Attachment 3: Responses to Issues Raised in Submission from Office of Environment & Heritage to the Department of Planning (20 December 2018)

Location	Drawing No:	Sheet:	Rev:
CHVA	49-BR-ARM01	DA5124	D
Sydney Opera House Trust GPO Box 4274 Sydney NSW Australia 2001 Phone: +61 2 9250 7541 email: info@sydneyoperahouse.com		© Sydney Opera House Trust

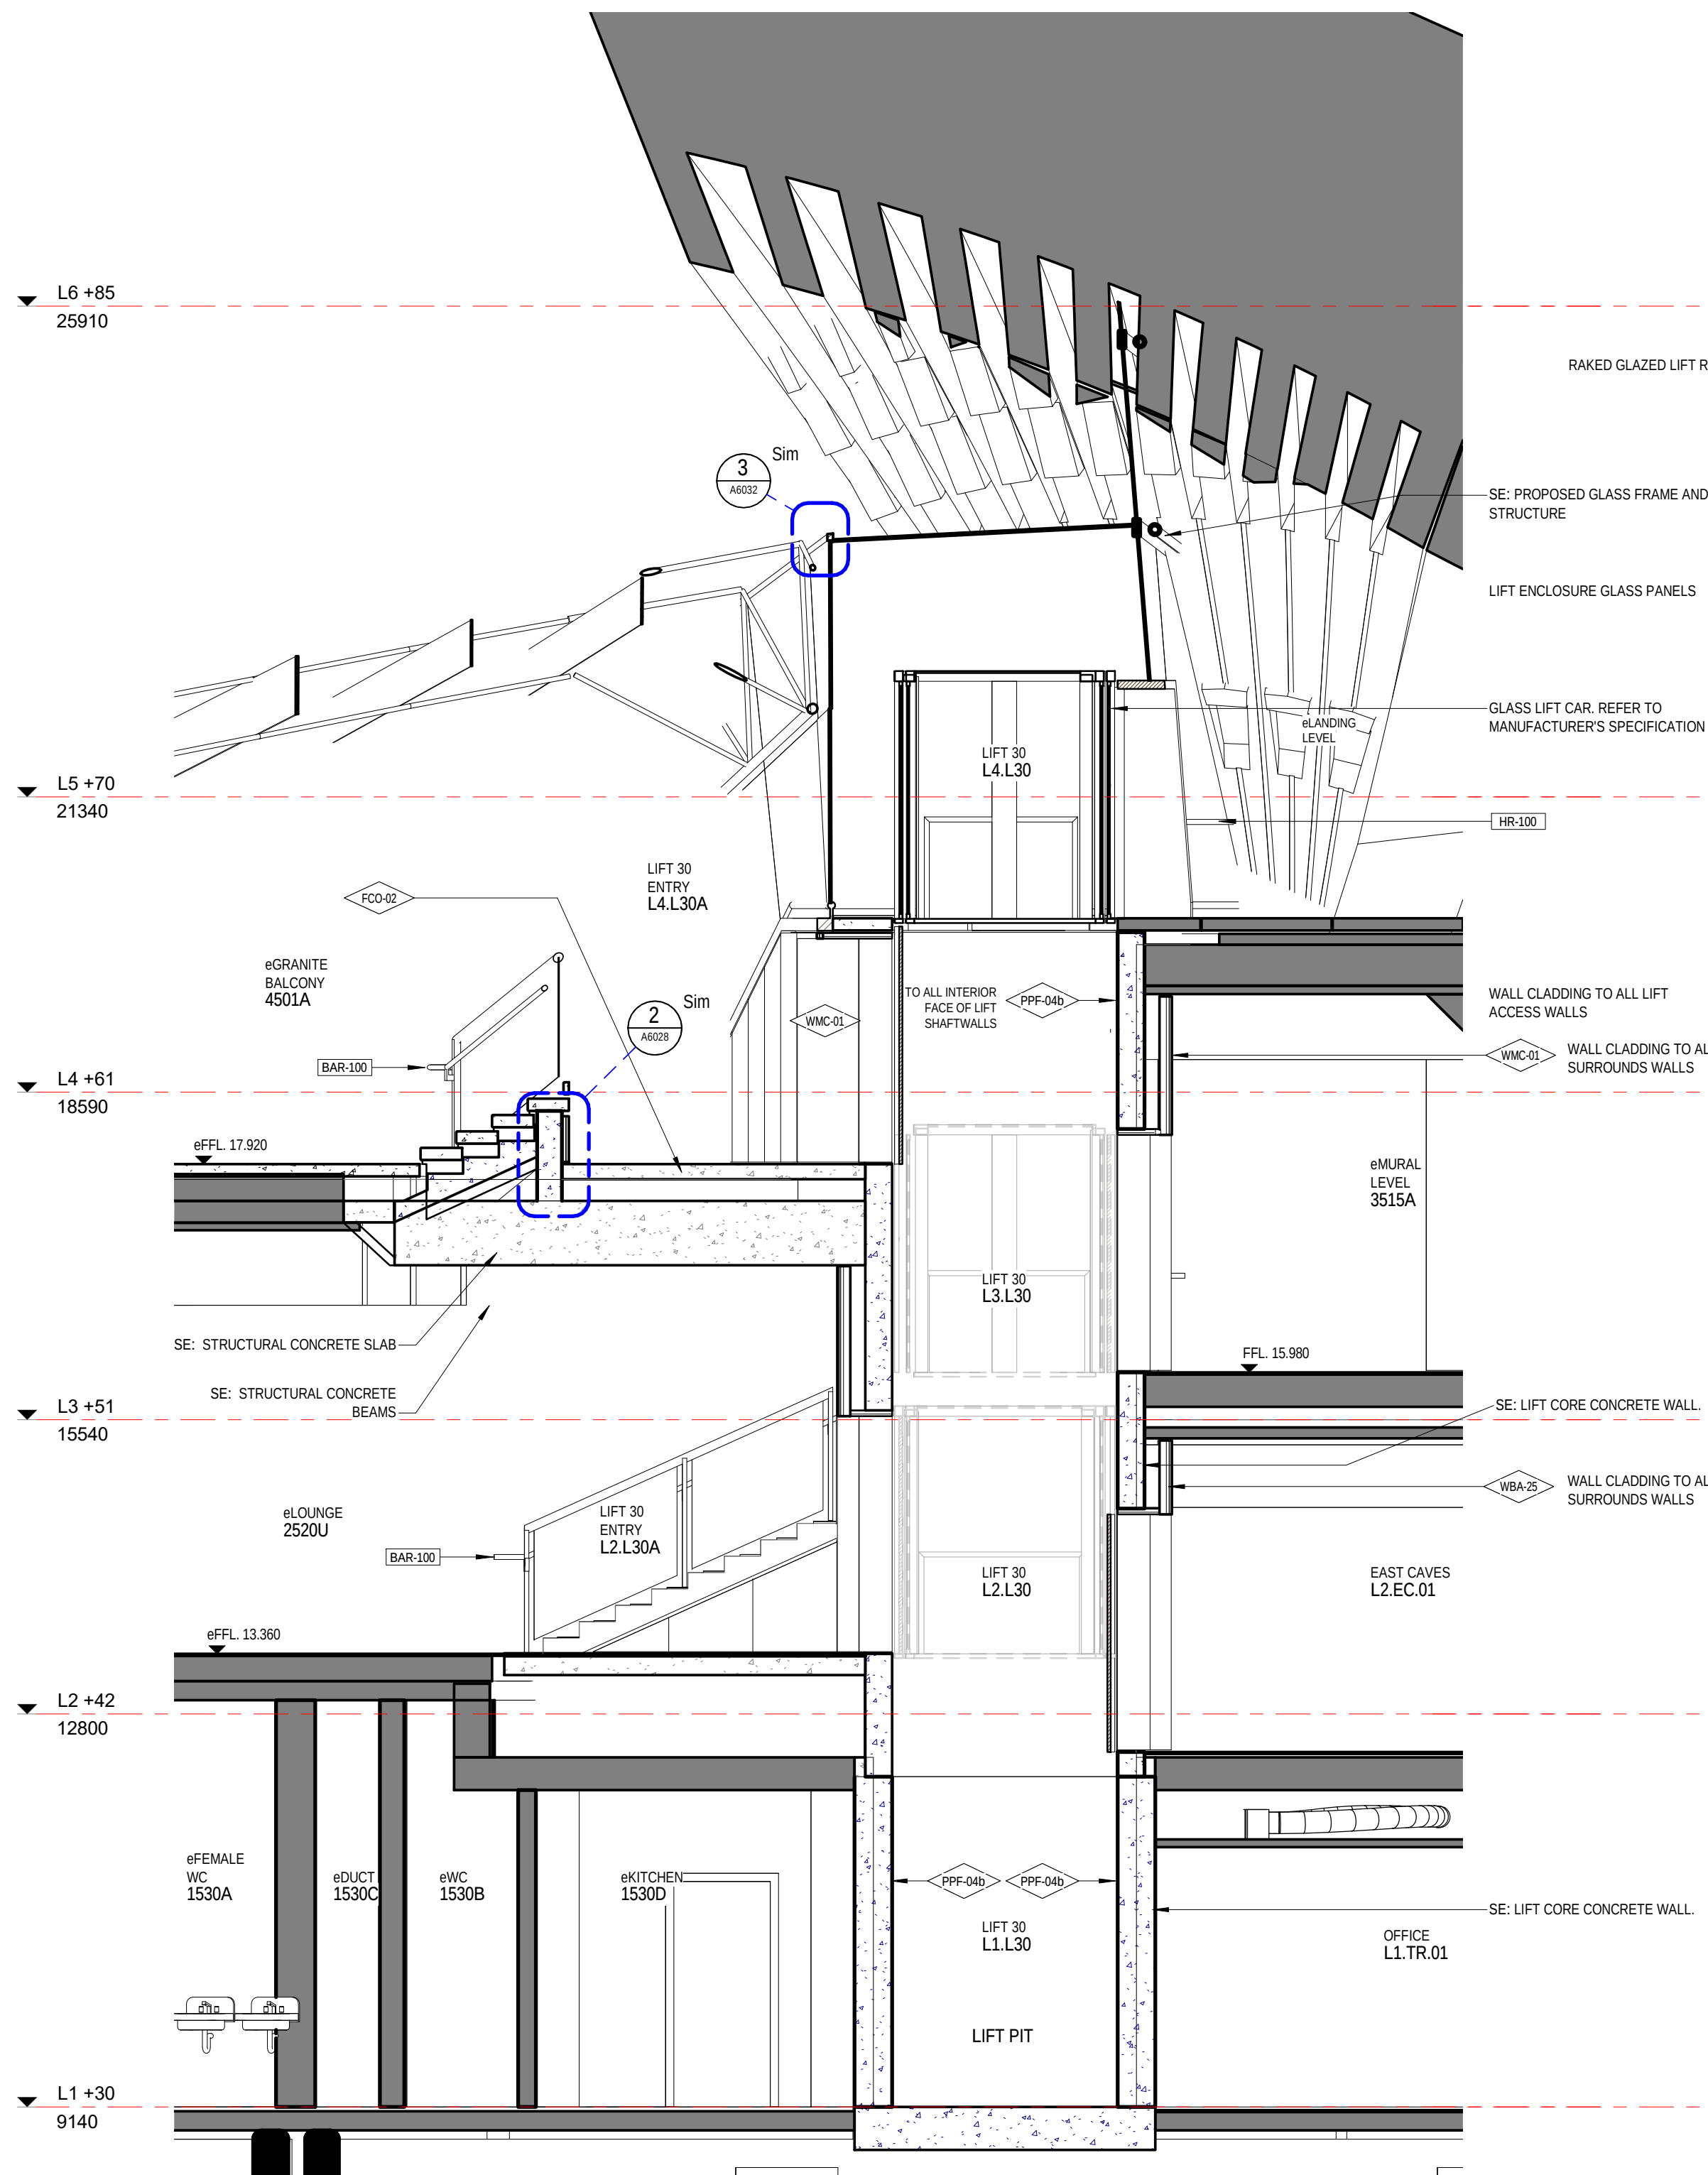
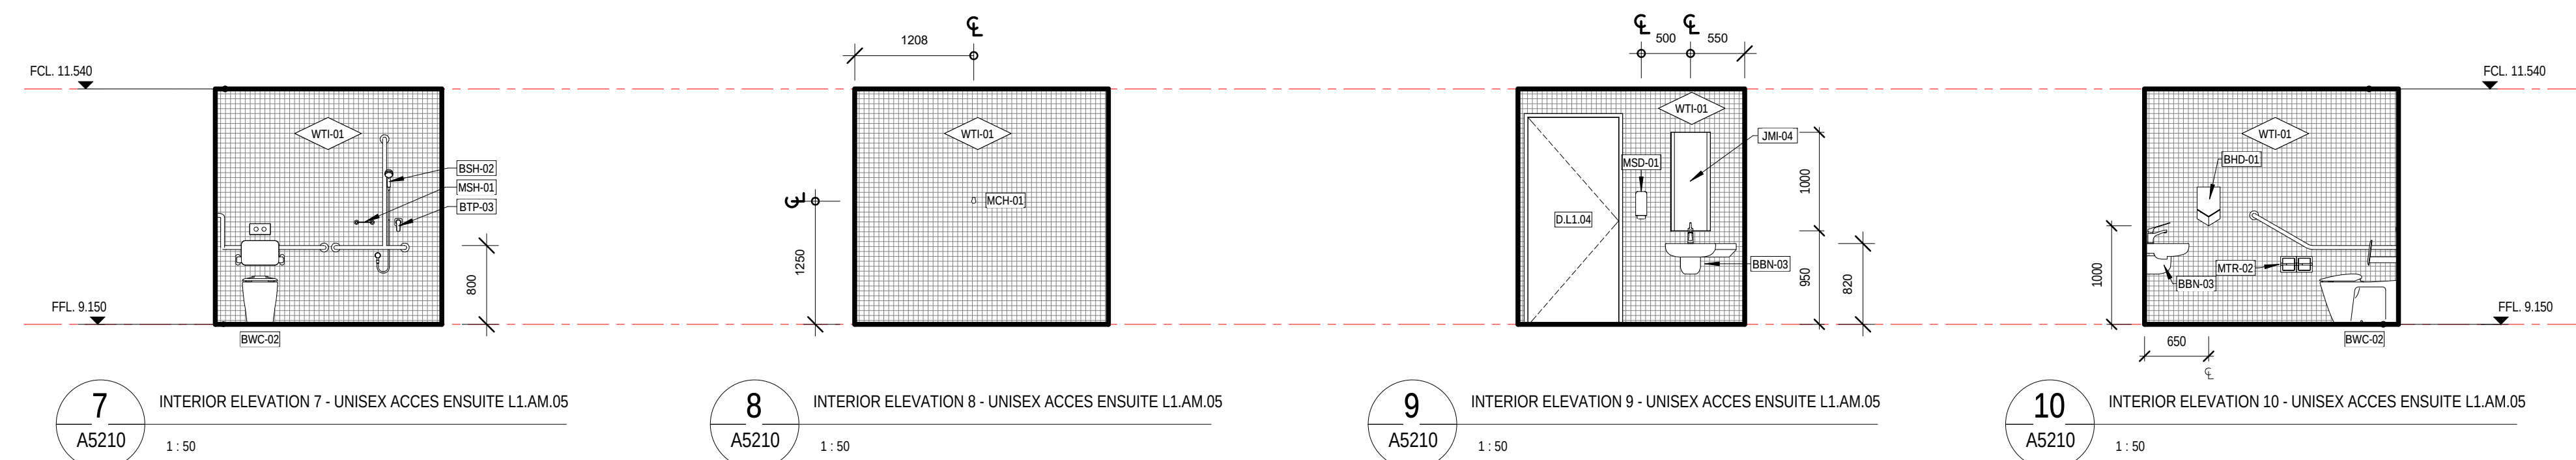
<p>4. Any archaeological impacts relating to lift base installations should identify the methodology for excavation, and include monitoring of the excavation by an archaeologist, recording of anything uncovered and the retention of as much as possible in-situ. This will ensure the proactive management and acknowledgement of any significant archaeology.</p>	<p>The construction of Lifts 29 and 30 in the Concert Hall Northern Foyer does not require any excavation below the existing floor level of Level 1 of the Sydney Opera House. This is shown in the vertical section plans of the lifts on drawings 49-BR-ARM01 Sheets DA5115 and DA5126.</p> <p>These lifts are similar to Lift 31 recently completed in the JST Northern Foyer. The lowest point of construction for this lift is Level 1, where the lift pit is situated. These lifts are quite distinct from new Lift 36 in the JST Southern Foyer (under construction) which requires excavation below Ground Level.</p>	<p>Plans DA5115 & DA5126</p>
